# CITY OF ALBUQUERQUE

June 22, 2016

**Re: HLP Endodontics  
10429 Lagrima Del Oro NE  
Requested for Permanent C. O. – Accepted  
Engineers Stamp Date 6/29/15 (F21D063)  
Certification dated: 6-2-16**

ENGINEER'S SEAL 6/29/15 DAVID SOULE P.E. #14522	10429 LAGRIMA DE ORO DENTAL OFFICE CONCEPTUAL GRADING AND DRAINAGE PLAN	DRAWN BY DEM DATE 4-14-15
	 Rio Grande Engineering 1808 CENTRAL AVENUE SUITE 201 ALBUQUERQUE, NM 87106 (505) 872-0088	SHEET # 1 of 2 JOB # XXXXX

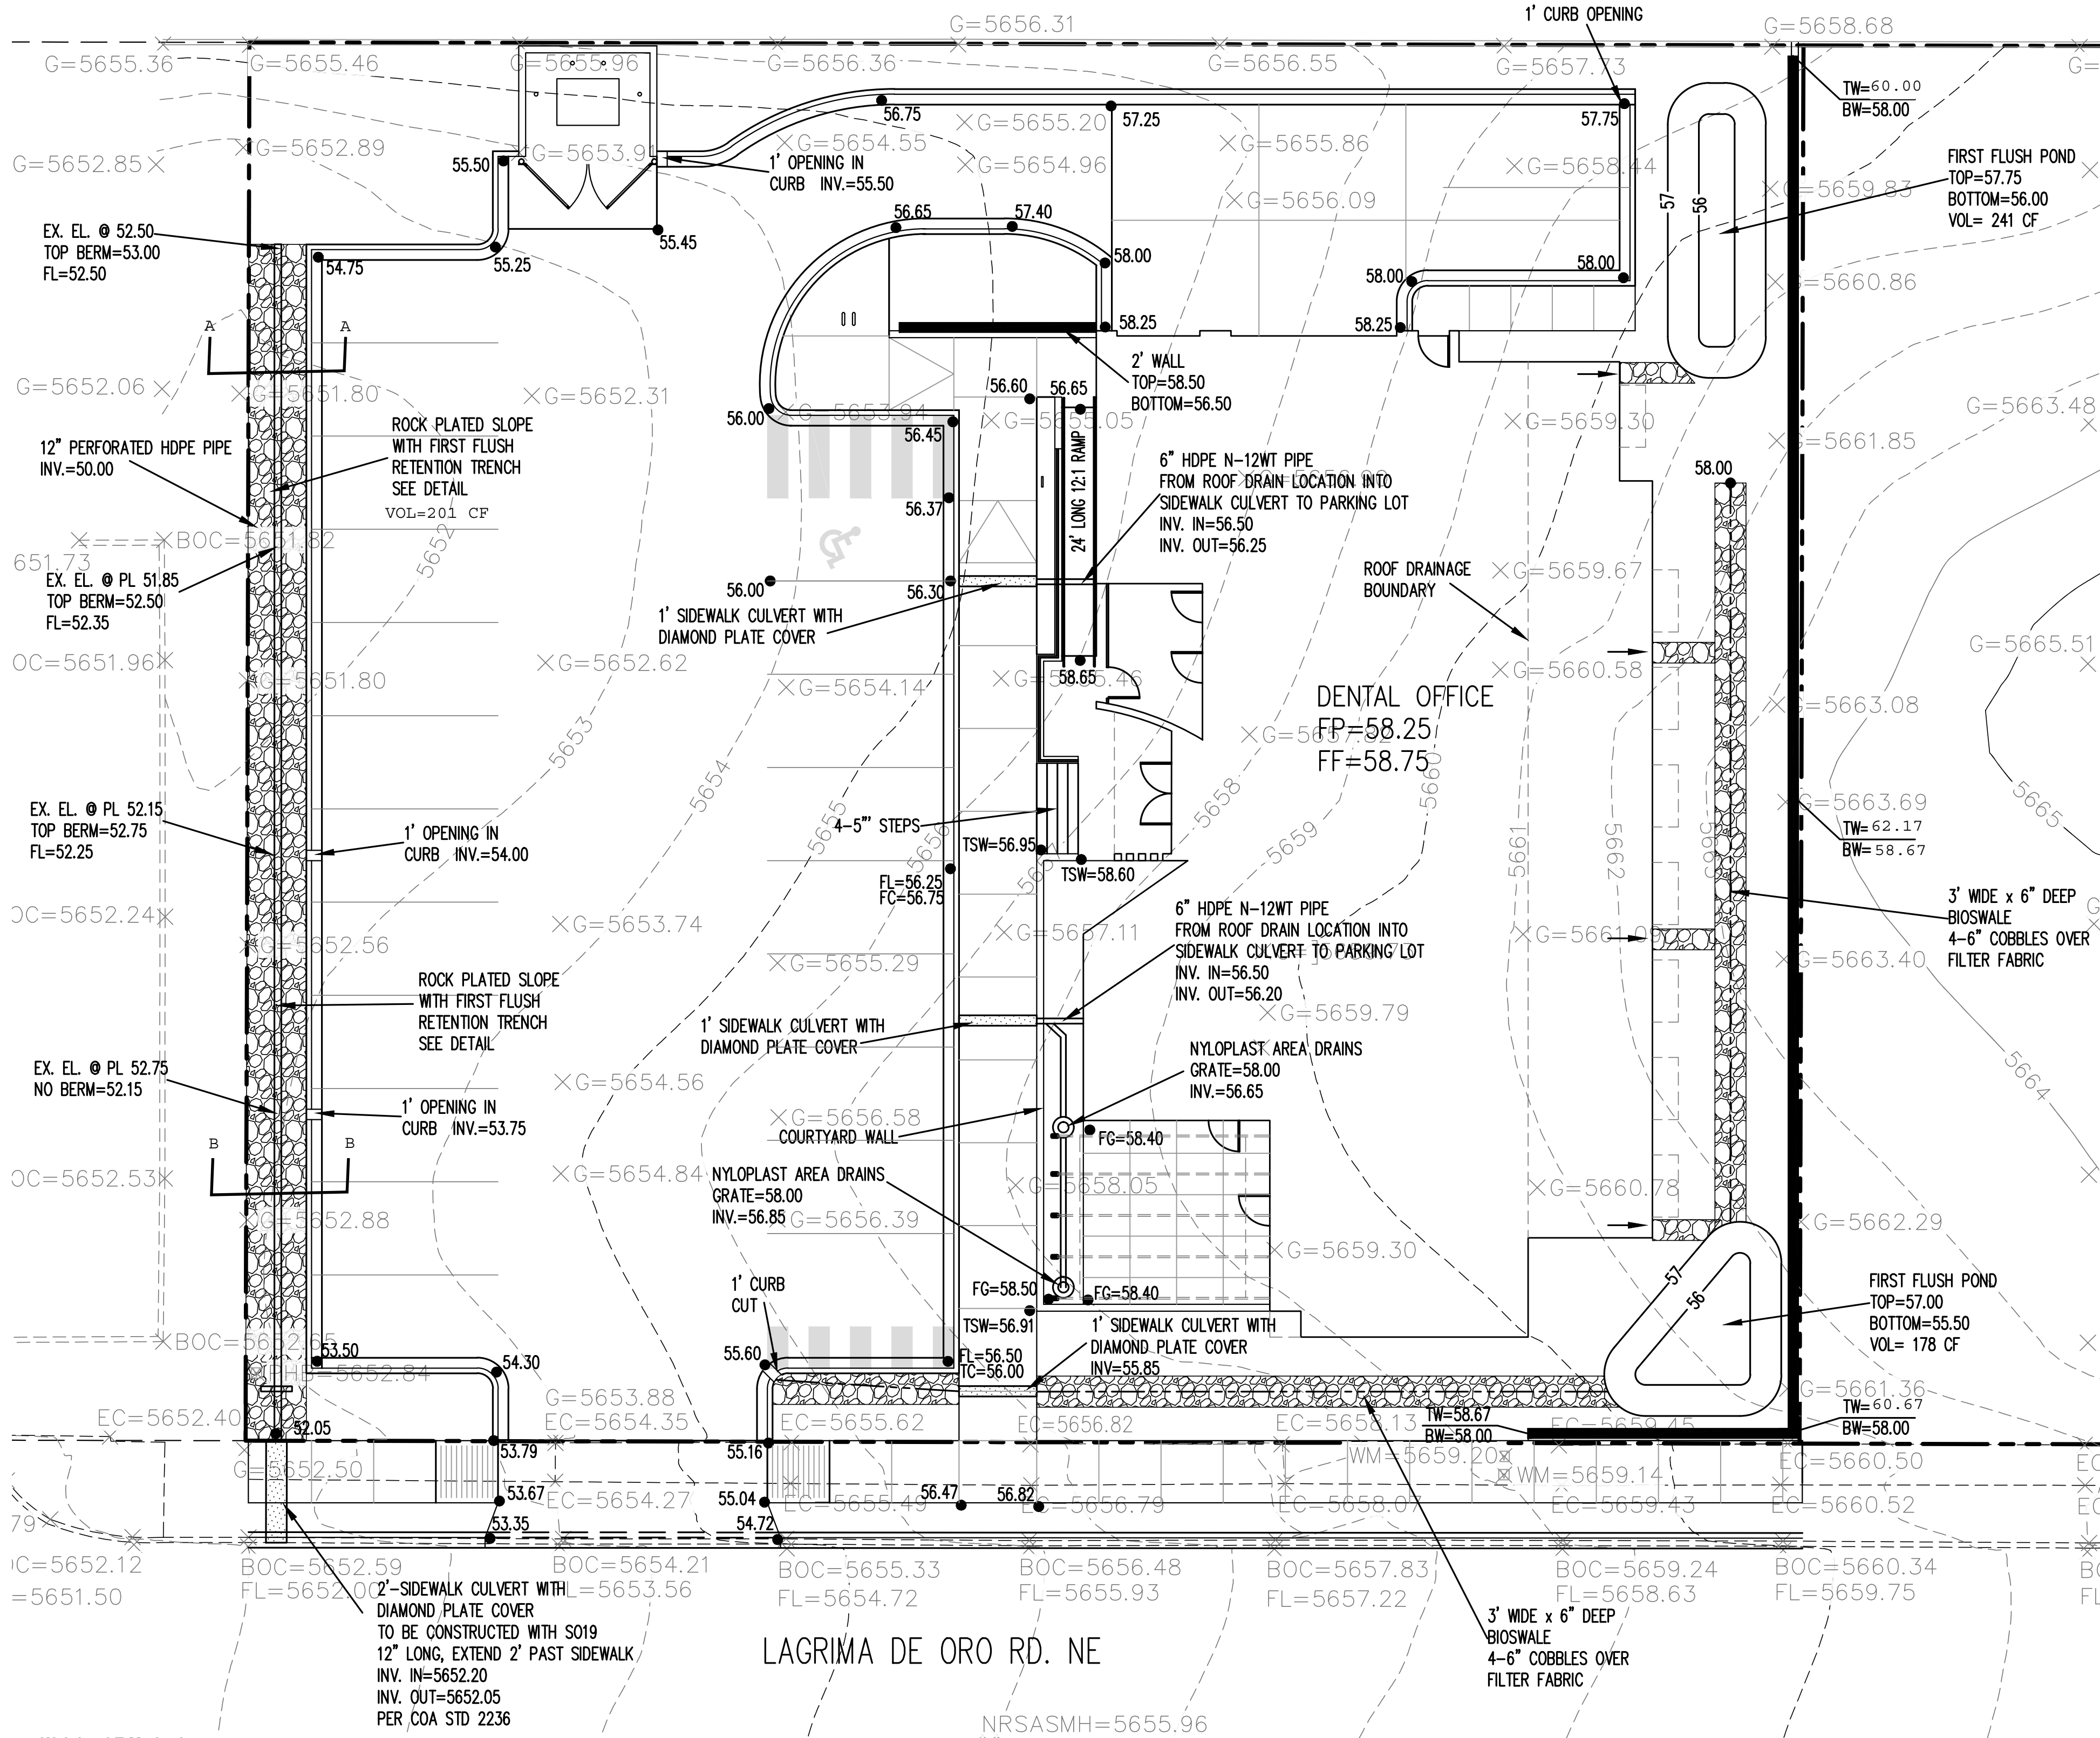
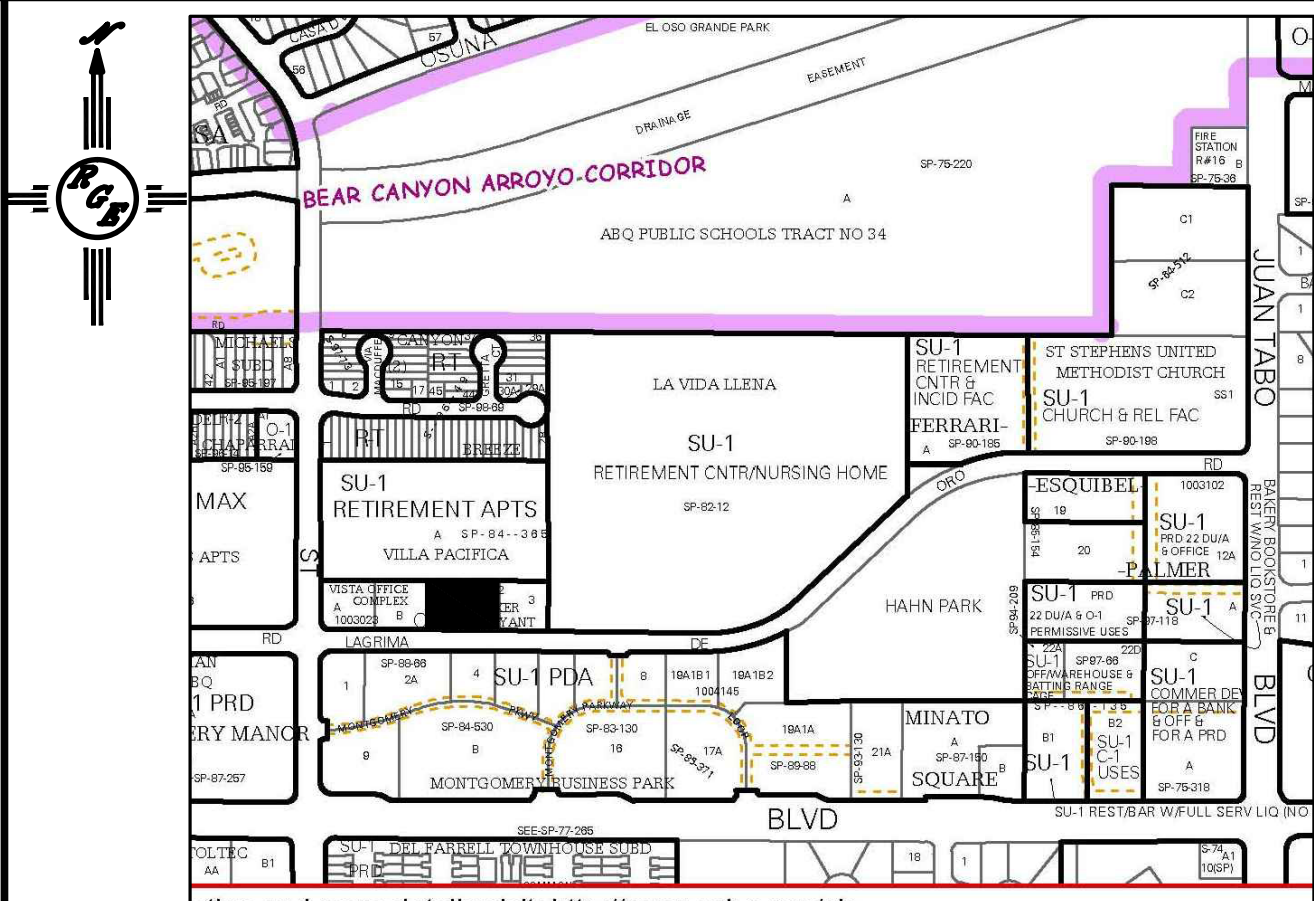
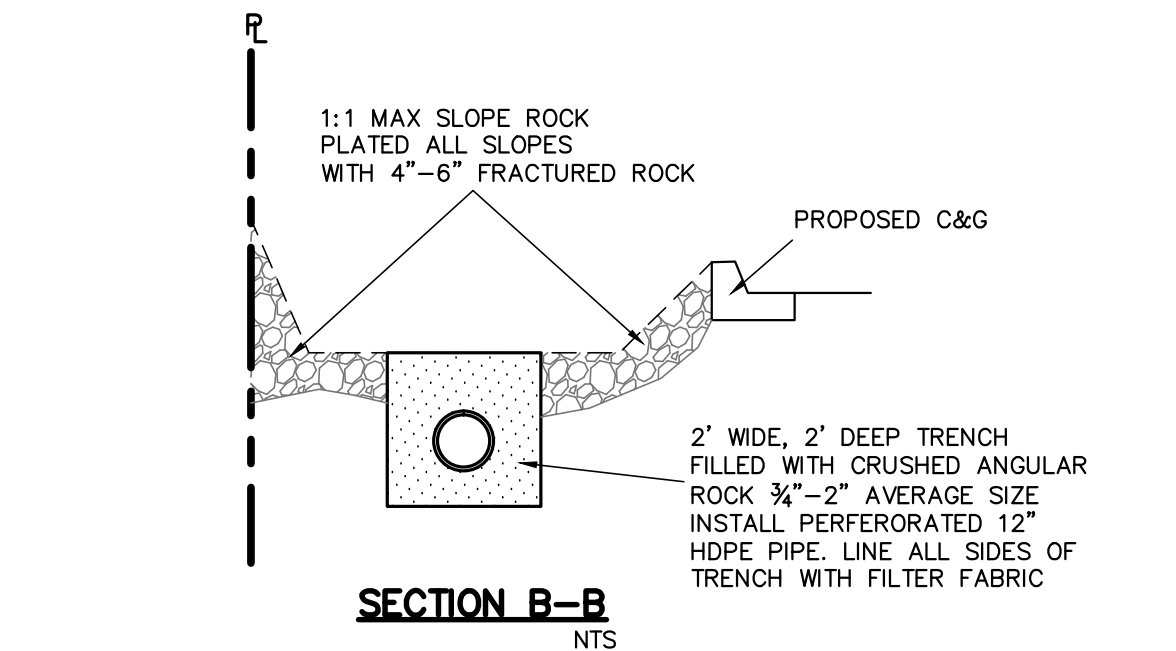
- Ensure that the transformer placed in the middle of the pond does not flood during a rain event. Contact PNM if necessary for recommendations.

- Both 1'-0" curb openings on the north end are missing. **WE OMITTED THE CUTS**
- There is a transformer where the pond at the NE corner was approved. New drainage flows are not as-built on the drawing. **WE CORRECTLY SHOWED POND AND OMITTED CUTS ALLOWS FOR COMPENSATORY FIRST FLUSH VOLUME**
- Only a portion of the rock plated slope w/ retention trench is constructed on the west side. Per the superintendent on site, the portion not constructed is being changed to a retaining wall. This has not been as-built on the drawings. **WE CORRECTLY SHOWED THE WALL**
- The SO-19 sidewalk culvert should be poured monolithic. Culvert should be 2'-0" however it only measures 1'-4". **THE CULVERT WAS REPLACED**
